**RE: ENGINEER'S CERTIFICATION FOR LOT 17-A MERIDIAN BUSINESS PARK
(K10/D34) ENGINEER'S STAMP DATED 1/5/99**

RE: REVISED DRAINAGE PLAN FOR LOT 17-A MERIDIAN BUSINESS PARK
(K10-D34) REVISION DATED 5/11/98

RE: DRAINAGE PLAN FOR LOT 17-A MERIDIAN BUSINESS PARK (K10-D34)
ENGINEER'S STAMP DATED 4/13/98

GRADING AND DRAINAGE PLAN  
FOR  
LOT 17-A, MERIDIAN BUSINESS PARK

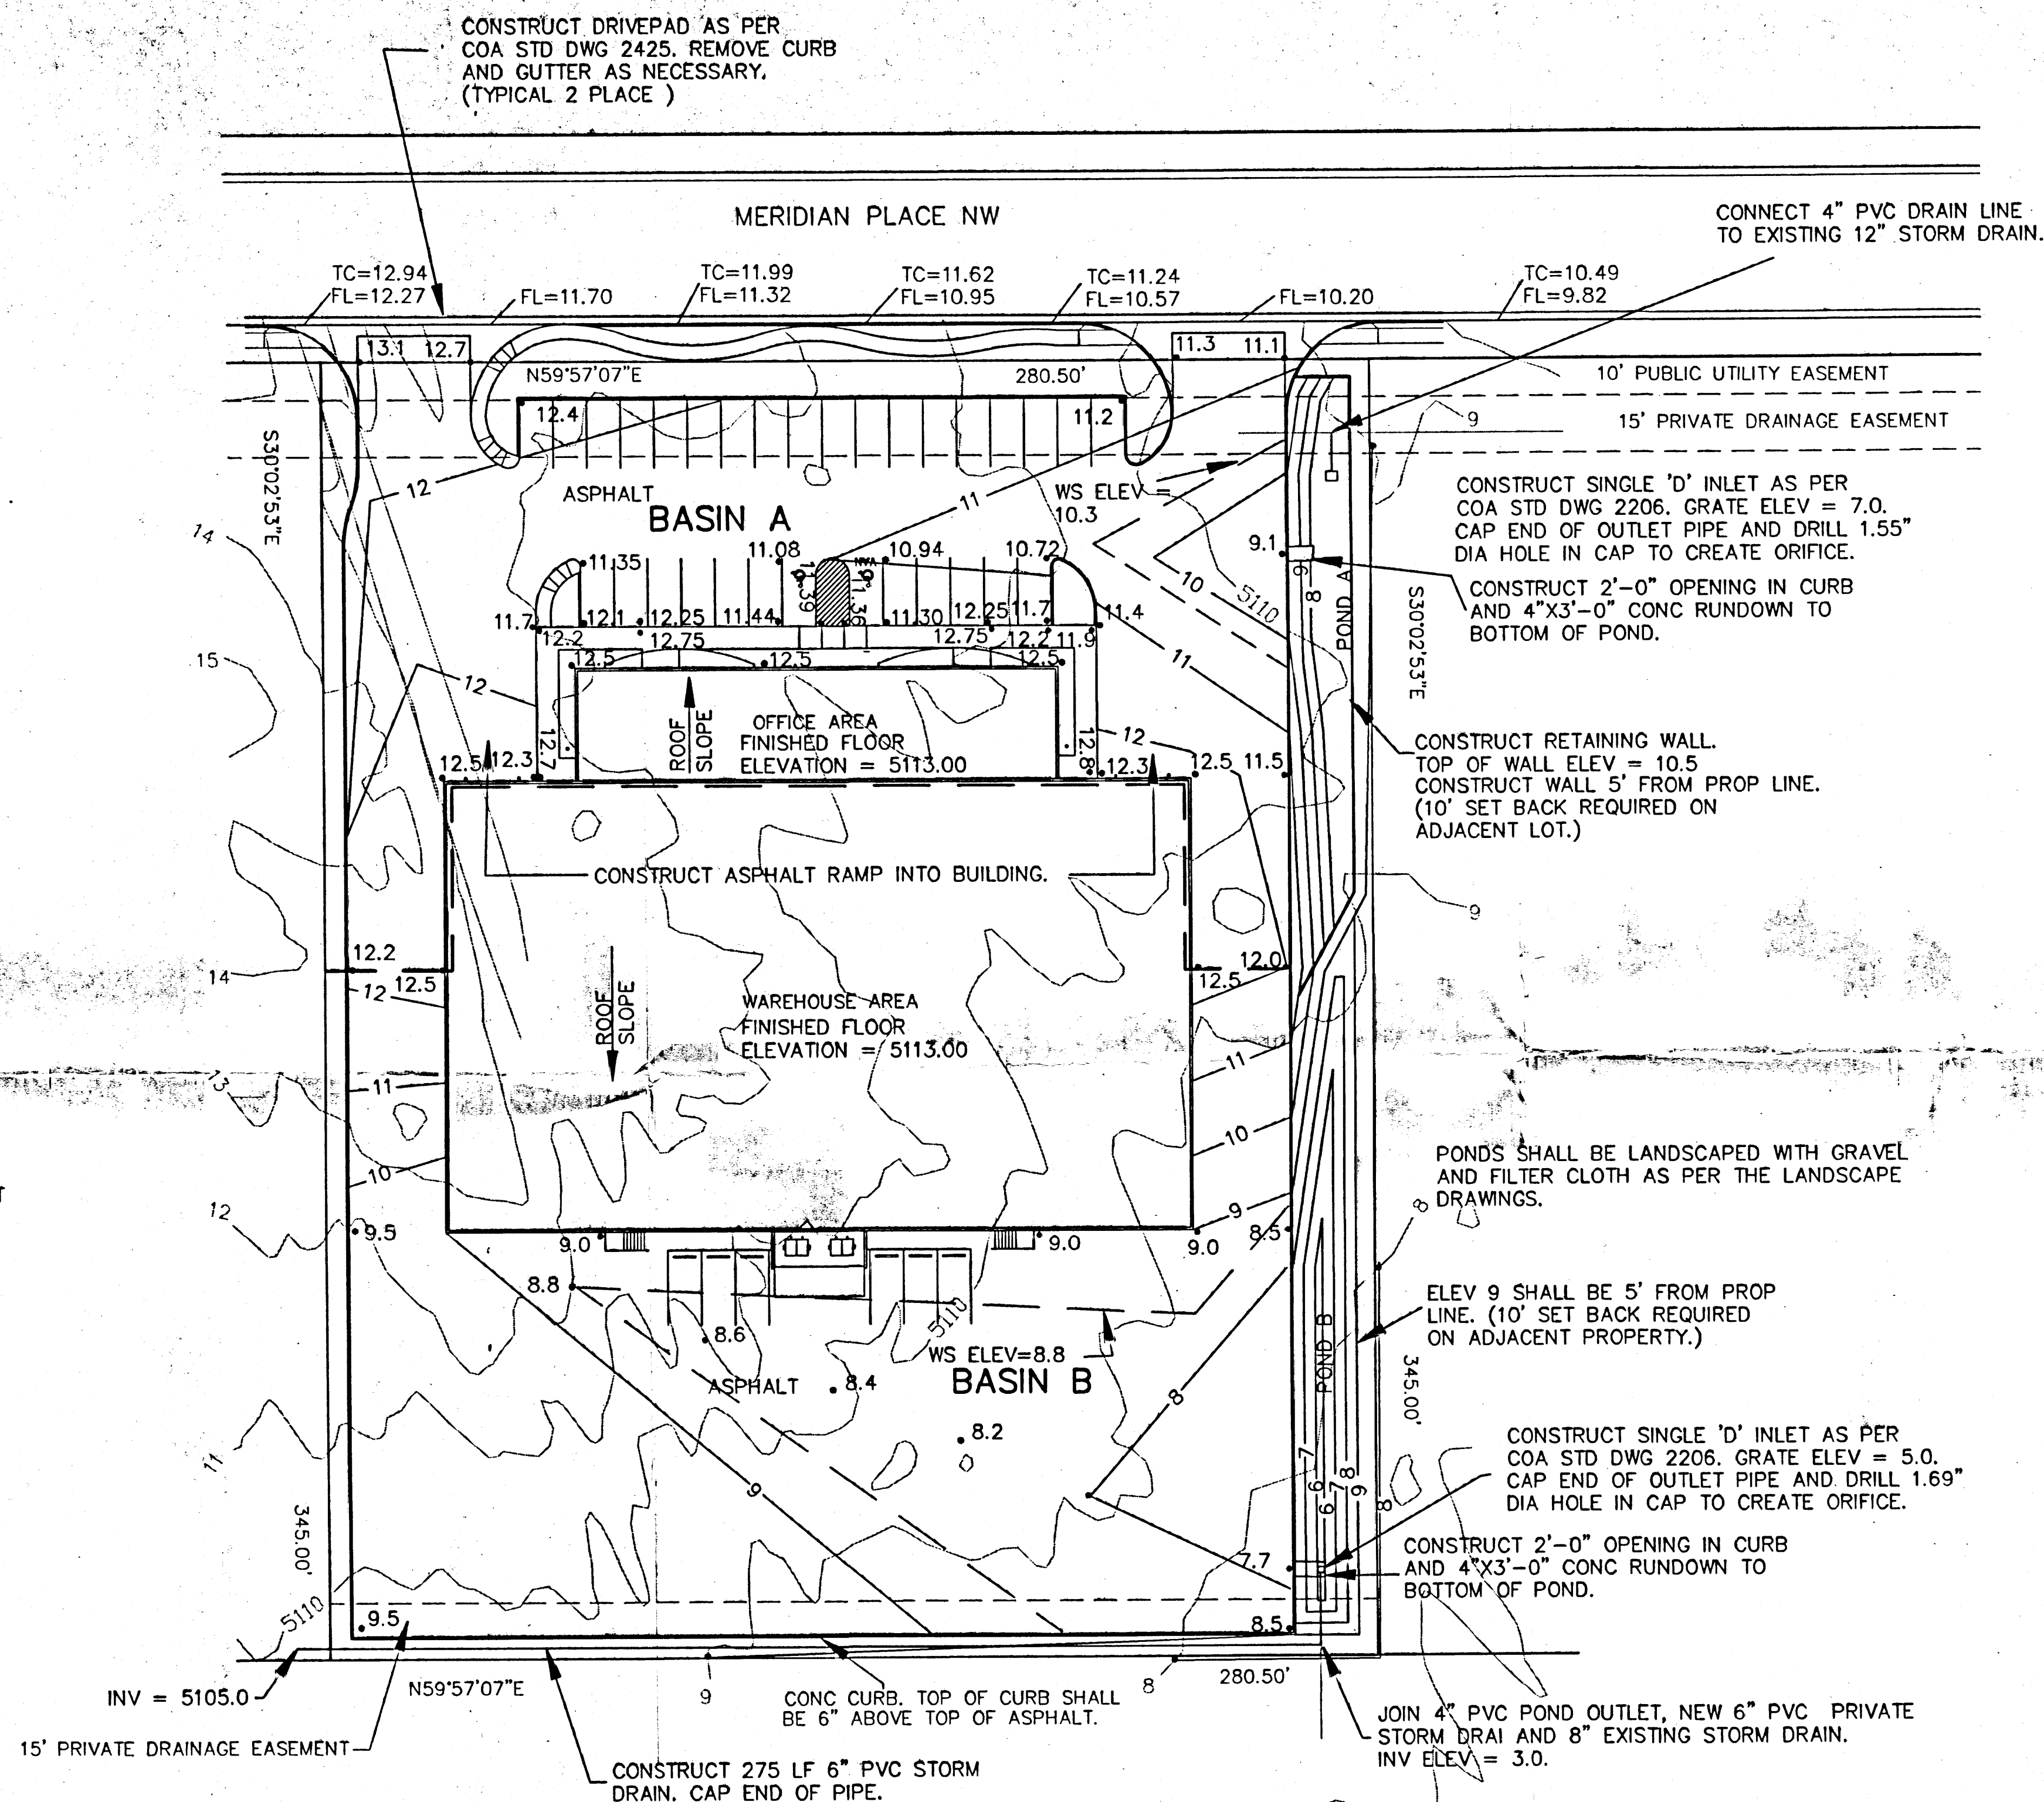
1. Address the closeness of the ponds to the adjacent property to the east. The DPM checklist will give you information as to how close you can be to a property line.
2. What type of erosion & sediment control to you propose within the ponding areas?
3. Extension of the pipe towards the west edge of the west property line to allow Lot 17-B to drain through the easement.
4. Indicate how and where the proposed ties to the existing storm drain pipes will take place.
5. Detail of the proposed orifices.
6. Indicate the 100-year water surface elevation on the plan drawing for each pond.
7. Indicate the top of curb elevations on the perimeter curb.
8. Indicate the slopes within the asphalt areas.
9. Is the complete site going to be paved? If not, please indicate the limits.

1. Address the closeness of the ponds to the adjacent property to the east. The DPM checklist will give you information as to how close you can be to a property line.
2. What type of erosion & sediment control to you propose within the ponding areas?
3. Extension of the pipe towards the west edge of the west property line to allow Lot 17-B to drain through the easement.
4. Indicate how and where the proposed ties to the existing storm drain pipes will take place.
5. Detail of the proposed orifices.
6. Indicate the 100-year water surface elevation on the plan drawing for each pond.
7. Indicate the top of curb elevations on the perimeter curb.
8. Indicate the slopes within the asphalt areas.
9. Is the complete site going to be paved? If not, please indicate the limits.

1. The adjacent properties have a 10' setback so notes were added to the drawing to require a five foot setback to high water on this project.
2. The ponds will be landscaped with gravel, filter cloth and plantings.
3. The pipe to the west has been added to the drawing.
4. The ties to the existing system have been indicated on the drawing.
5. A note with each orifice instructs the contractor has to construct the orifice.
6. The 100-year water surface contour has been added to the drawing.
7. A note has been added to the drawing indicating that the top of curb elevation is 6" above the asphalt.
8. A note has been added to the drawing indicating the minimum allowable slope of asphalt.
9. Notes have been added to the drawing to indicate that the entire site will be developed and paved.

1. The adjacent properties have a 10' setback so notes were added to the drawing to require a five foot setback to high water on this project.
2. The ponds will be landscaped with gravel, filter cloth and plantings.
3. The pipe to the west has been added to the drawing.
4. The ties to the existing system have been indicated on the drawing.
5. A note with each orifice instructs the contractor has to construct the orifice.
6. The 100-year water surface contour has been added to the drawing.
7. A note has been added to the drawing indicating that the top of curb elevation is 6" above the asphalt.
8. A note has been added to the drawing indicating the minimum allowable slope of asphalt.
9. Notes have been add to the drawing to indicate that the entire site will be developed and paved.
